**APPLICATION BY FIVE ESTUARIES OFFSHORE WIND FARM LIMITED  
FOR AN ORDER GRANTING DEVELOPMENT CONSENT FOR THE FIVE ESTUARIES  
OFFSHORE WIND FARM PROJECT**

**(REF: EN010115)**

**DEADLINE 2**

**SUMMARY OF WRITTEN REPRESENTATION BY  
THE PORT OF LONDON AUTHORITY**

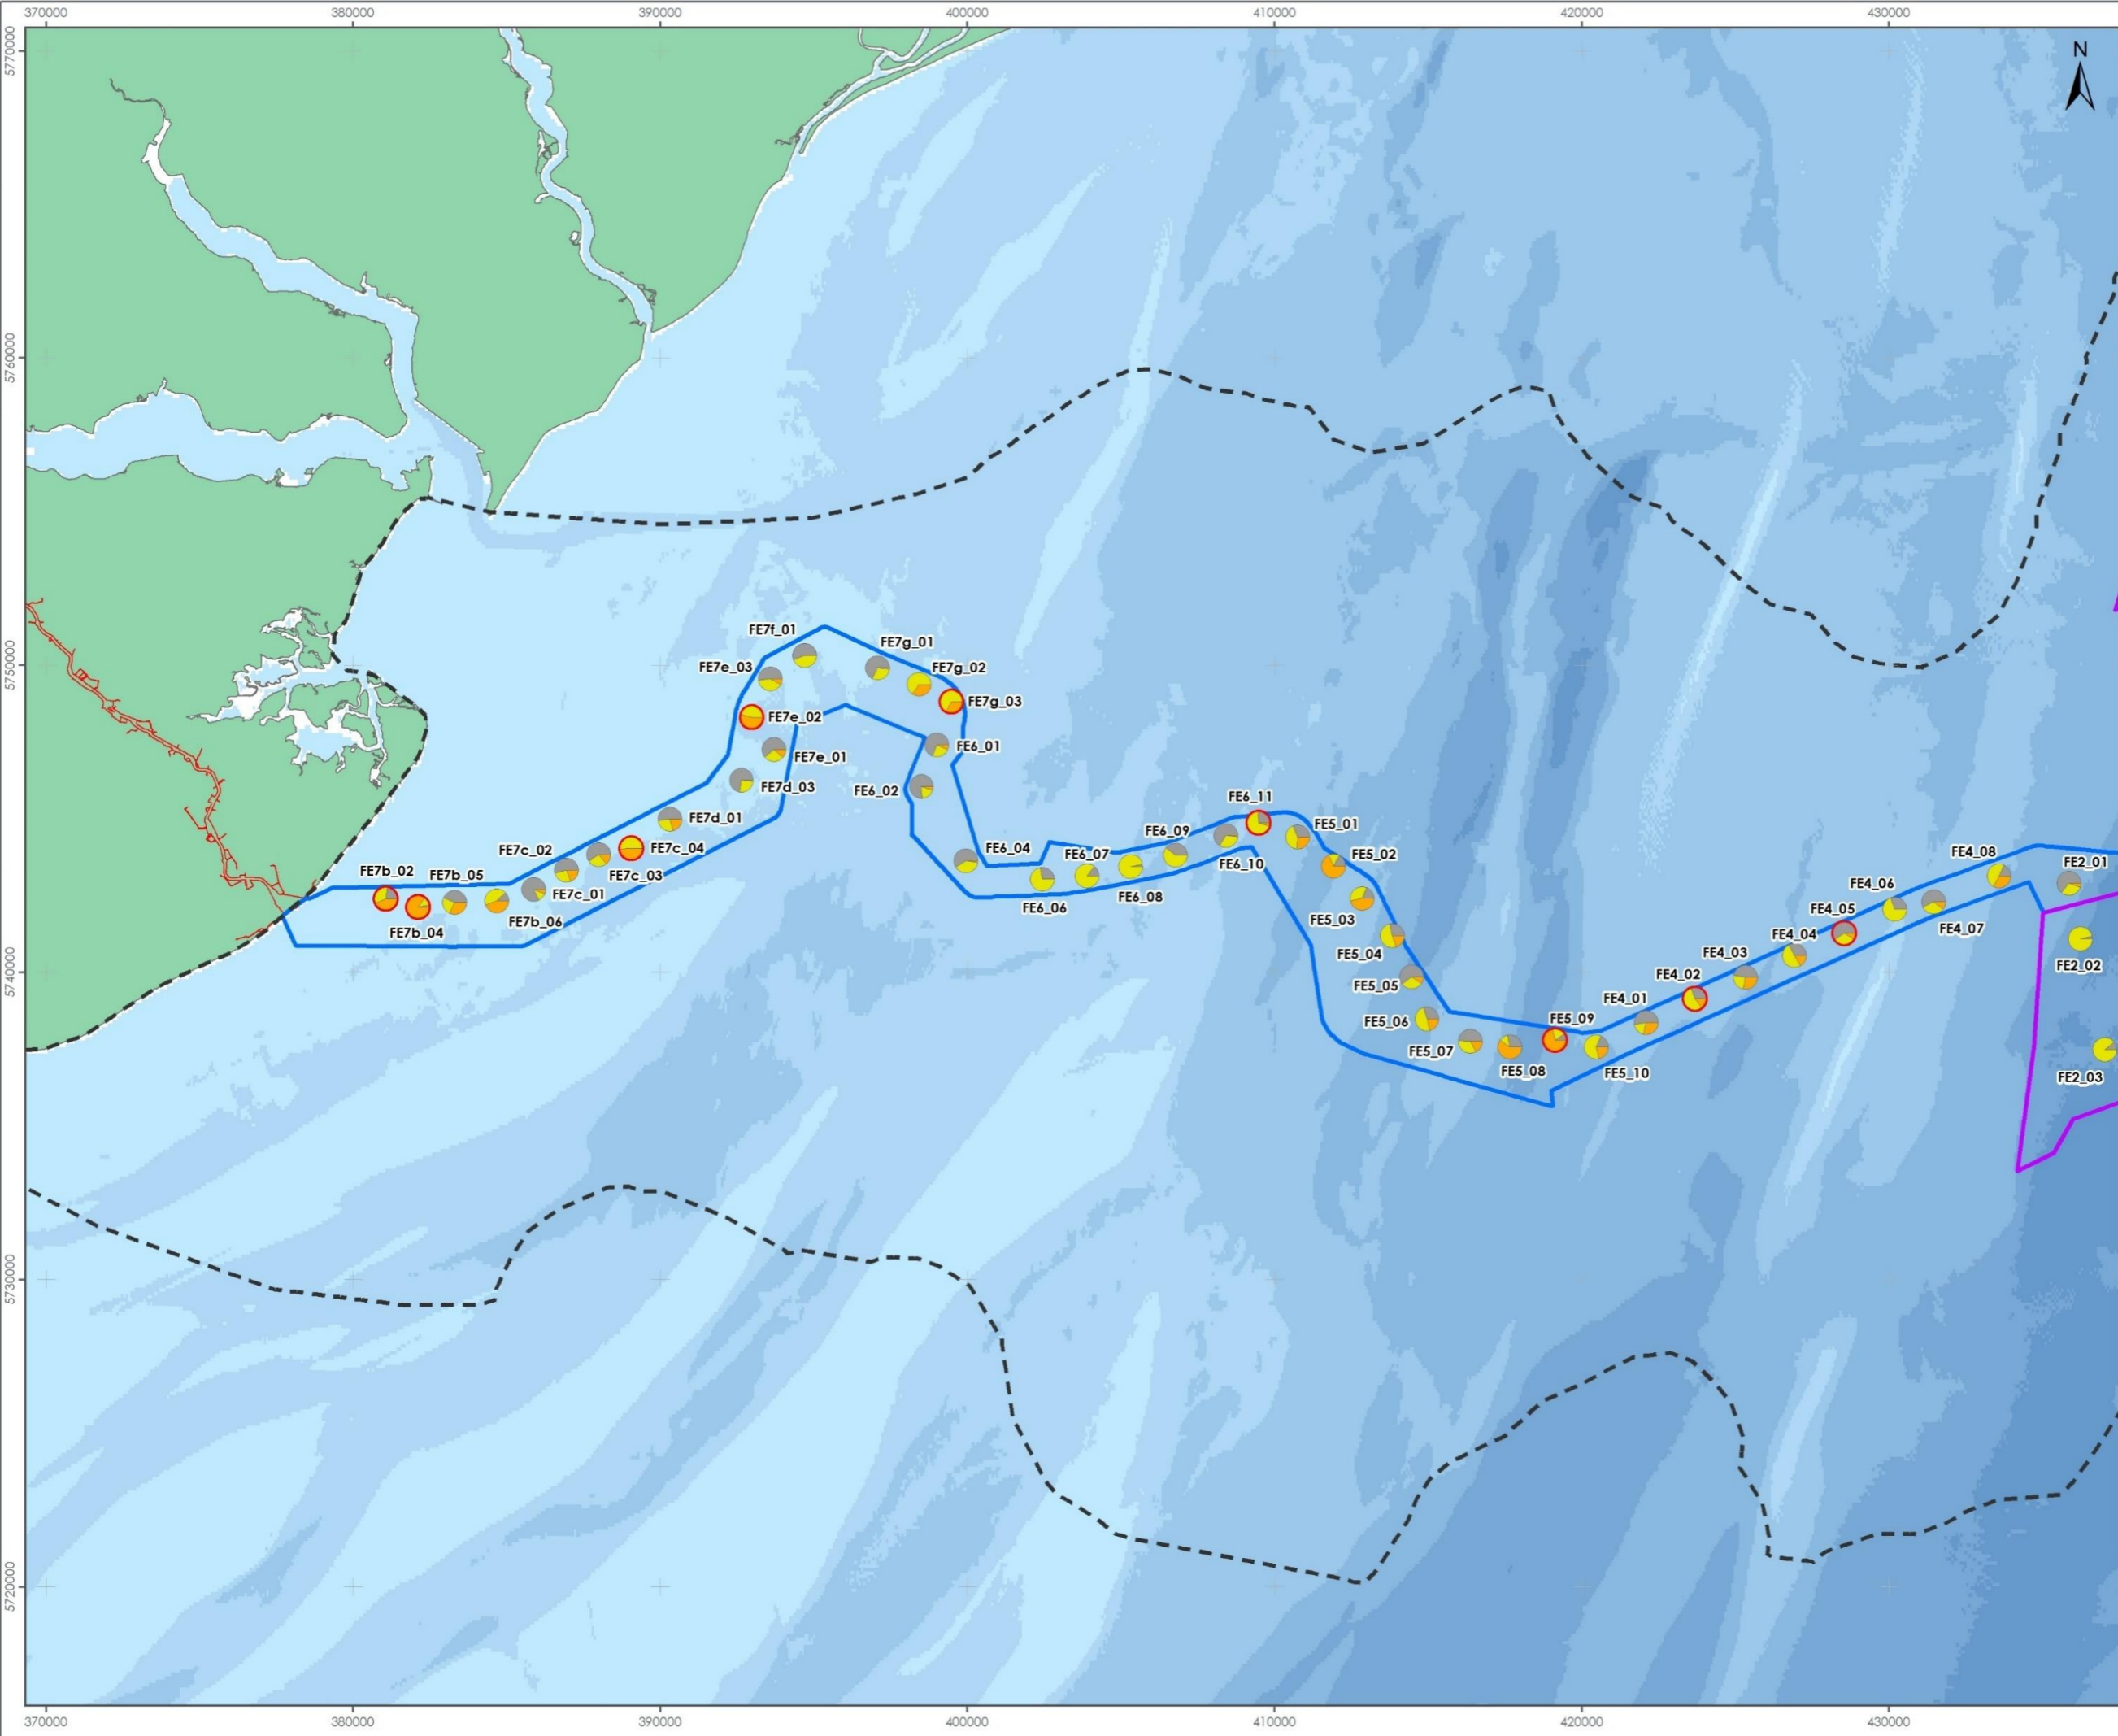
- 4.15 In order to install the cables within the ECC it will be necessary to dredge. The Marine Licence allows for up to 9,214,386 cubic metres of inert material to be deposited within Works no.2 (the ECC), 2A and 3. Fig 1.11 of the Offshore Project Description (APP-069) shows that the ECC disposal site is along the entirety of the ECC. There is a concern about a lack of controls in relation to the placing of inert material within the ECC and the implications of this for navigable depths at the DWRs.
